Subject: Y/88/21/DOC

Please see below the comments of our Drainage Officer.

Condition 5

SITE LAYOUT
(1:200)

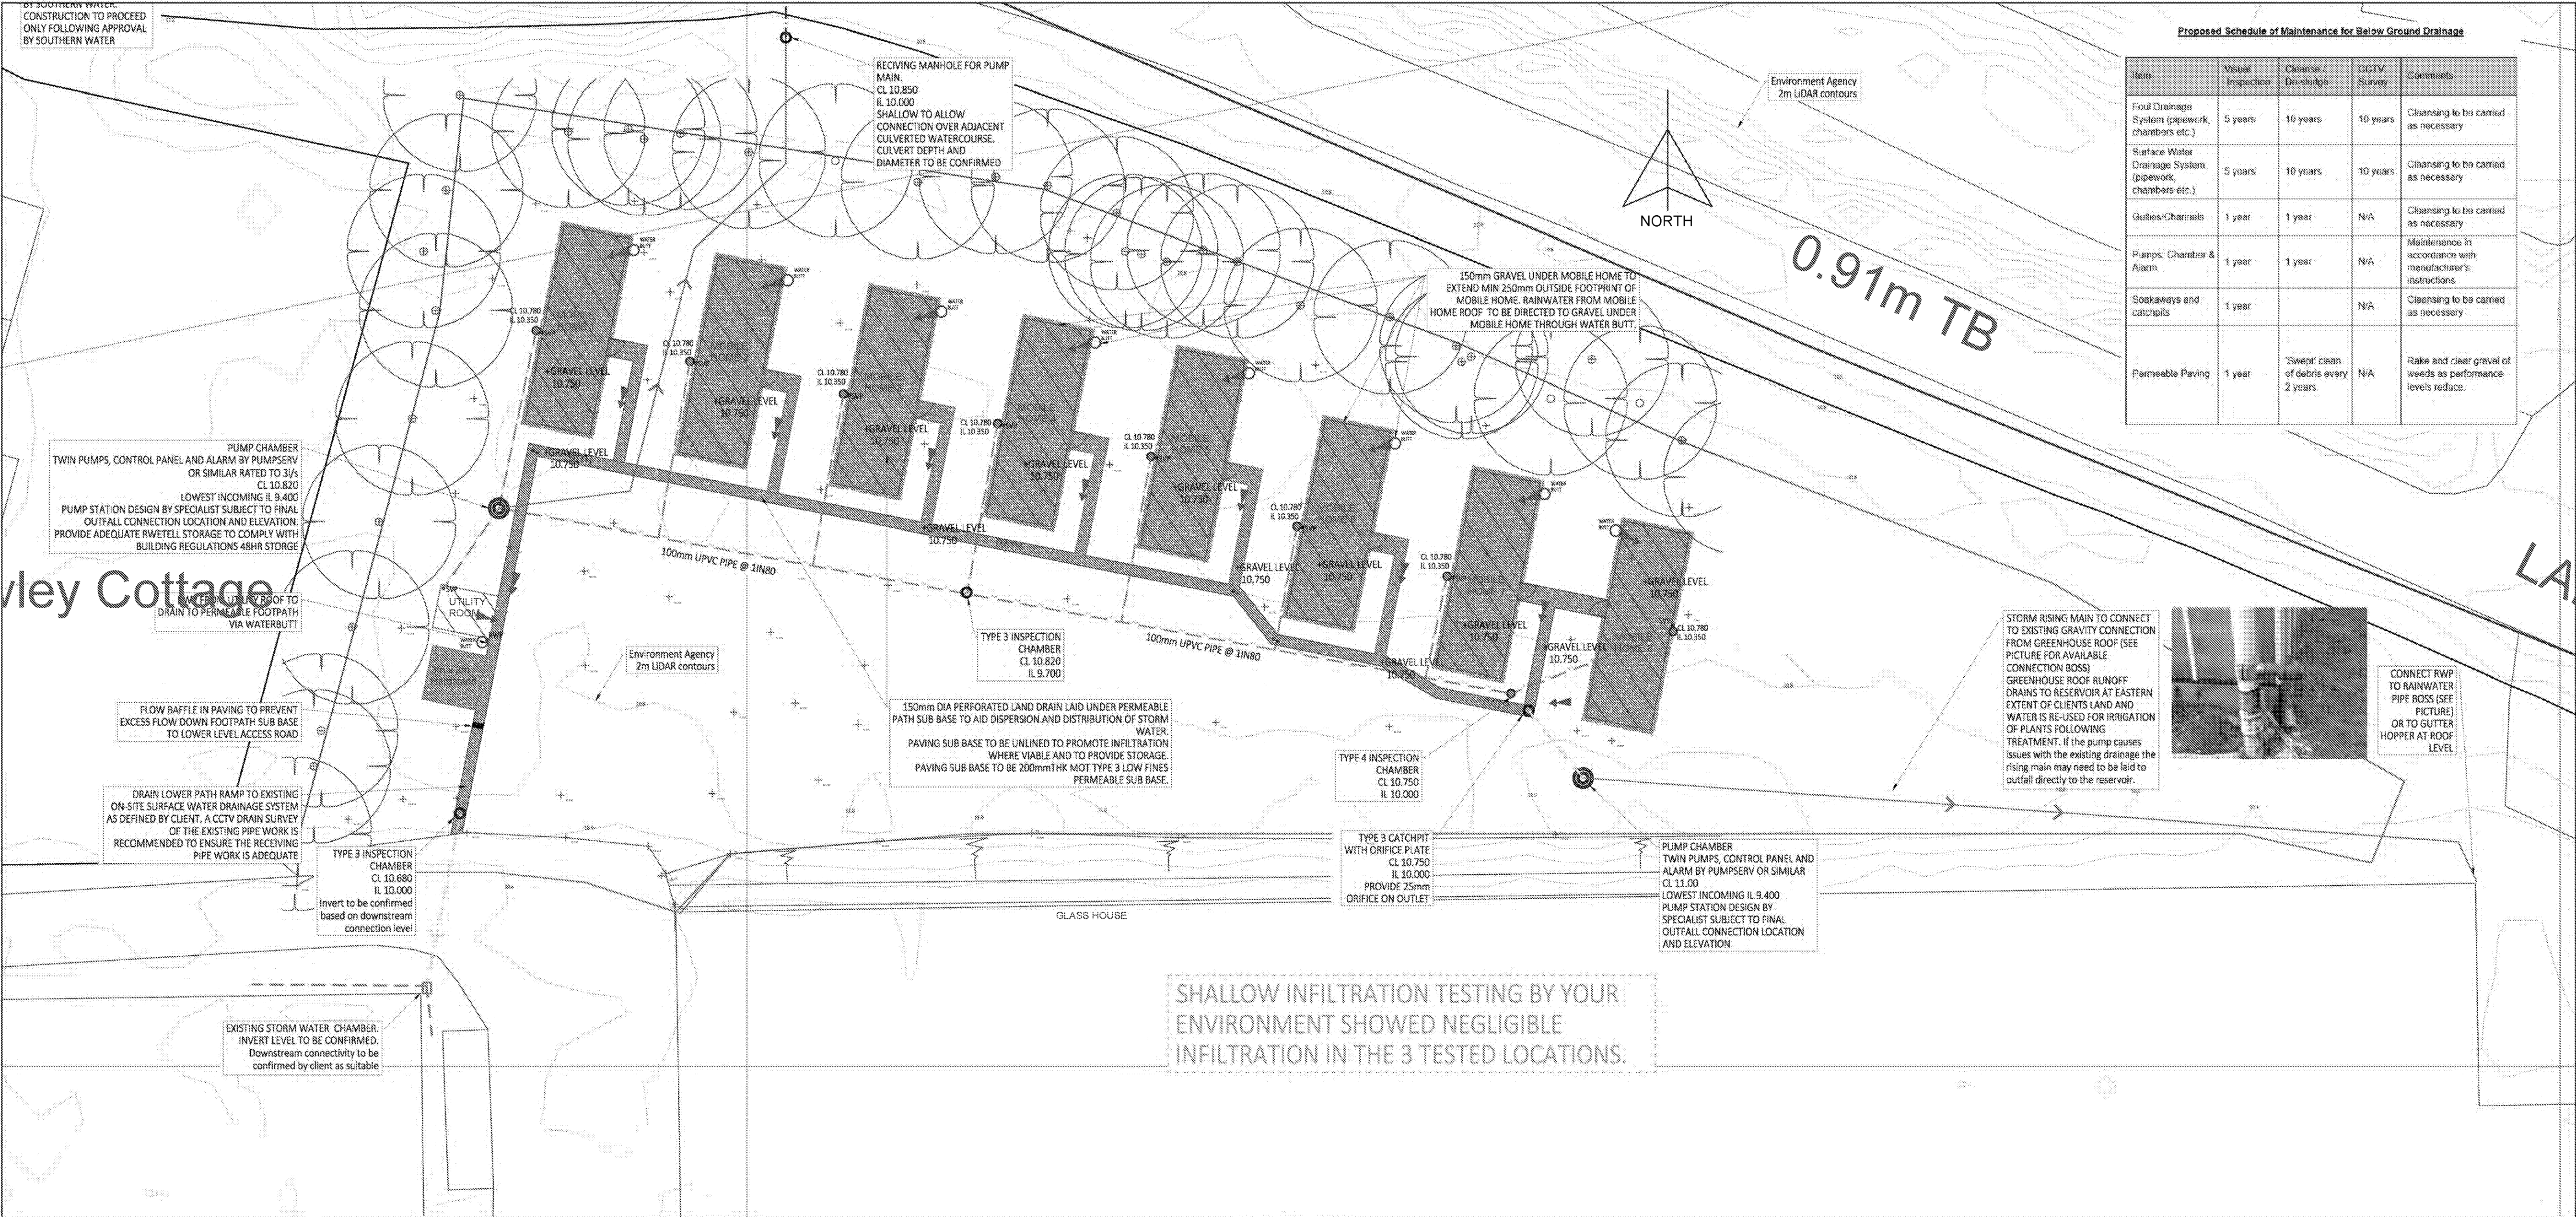
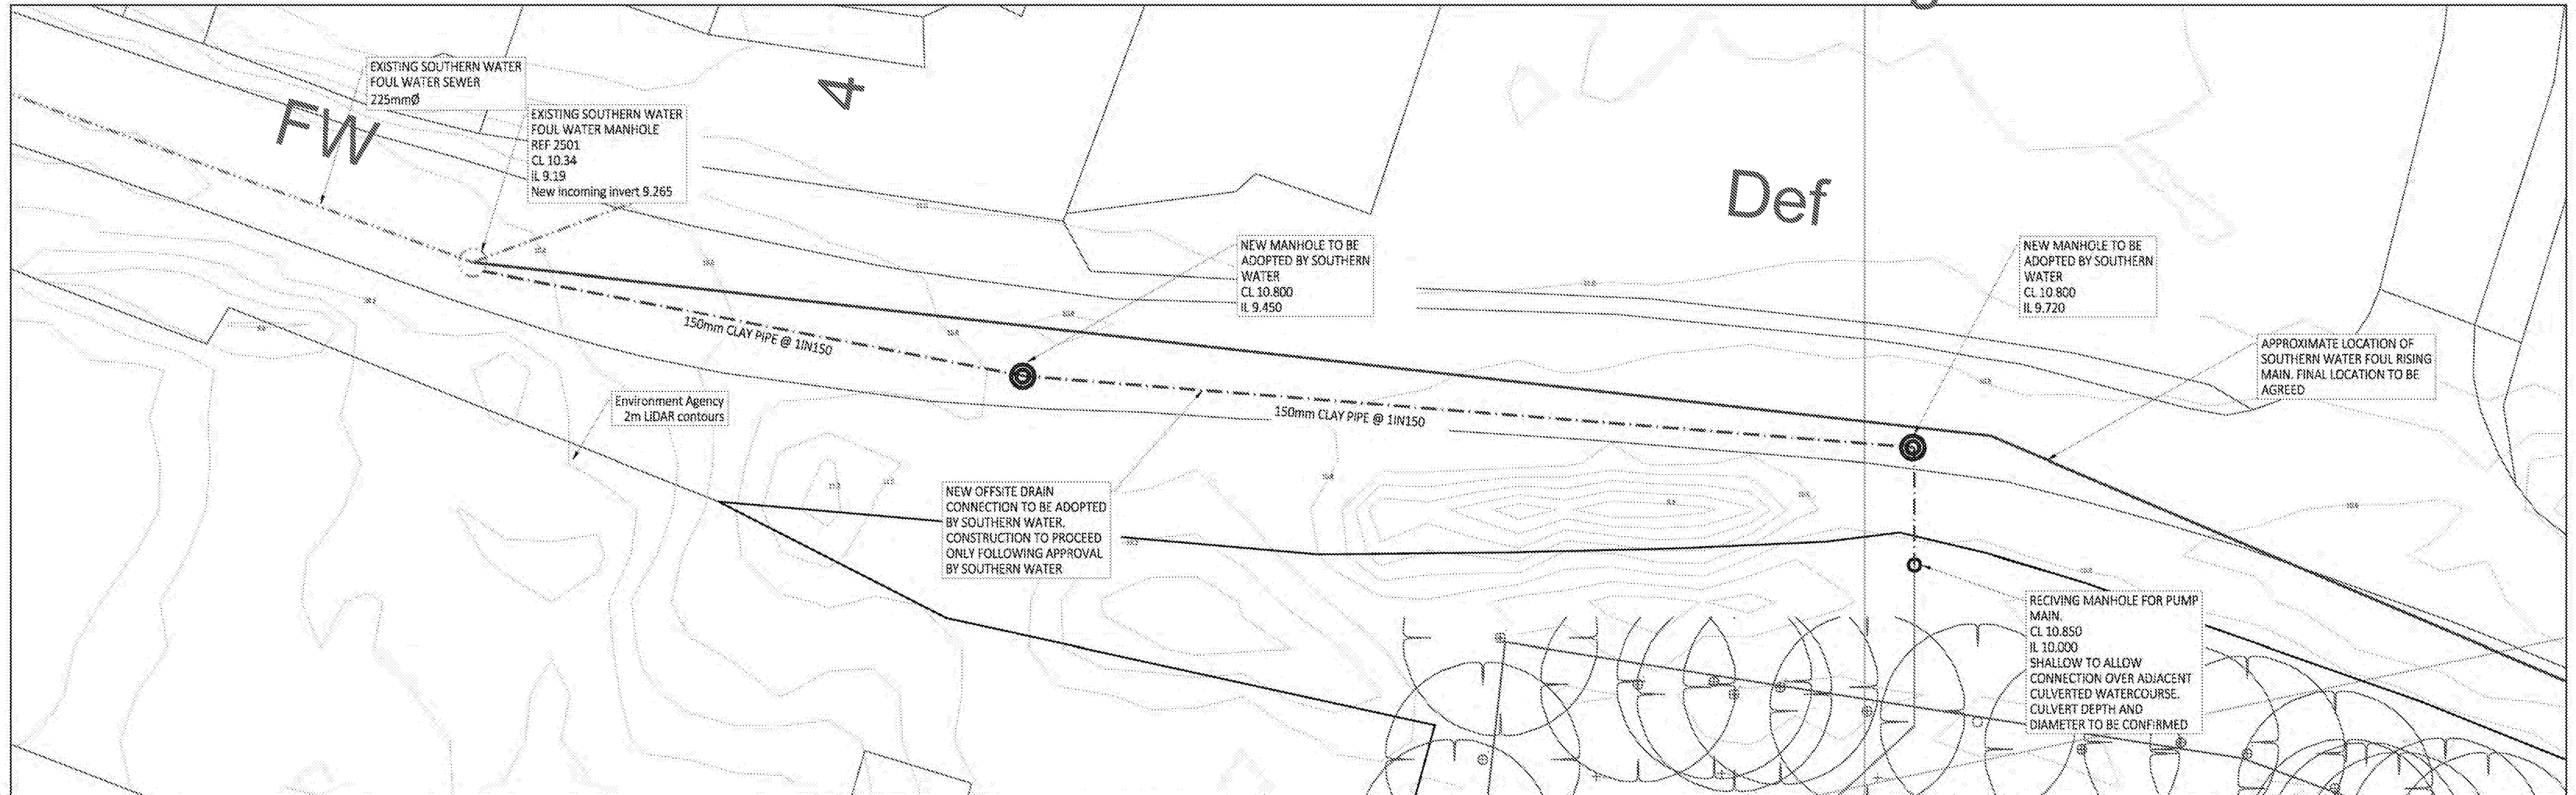
1. The applicant has completed summer infiltration testing which indicate infiltration is not viable.
2. No winter groundwater monitoring results have been provided, this information must be supplied to evidence that groundwater will not get into the surface water drainage system.

3. The proposal is for an unlined system to be pumped. This could in winter result in groundwater being pumped.
4. Pumping is not supported, it is not a sustainable solution. Pumps also fail and can result in increased flood risk both on and off site. The applicant must submit a revised gravity scheme.

5. The proposals are to pump surface water to the on site reservoir. The statement claims that no surface water will be discharged off site. No evidence has been submitted to evidence that either the existing surface water drainage network or reservoir have the capacity to accept these additional flows. The reservoir must also have an overflow to somewhere for water to be discharged in times of exceptional rainfall when irrigation demands are less, i.e. the winter. Therefore the statements provided are not supported by ourselves.

It is not possible for us to recommend discharge of this condition at this time with the strategy presented. A fully revised surface water drainage design is required, which may involve a gravity outfall to watercourse.
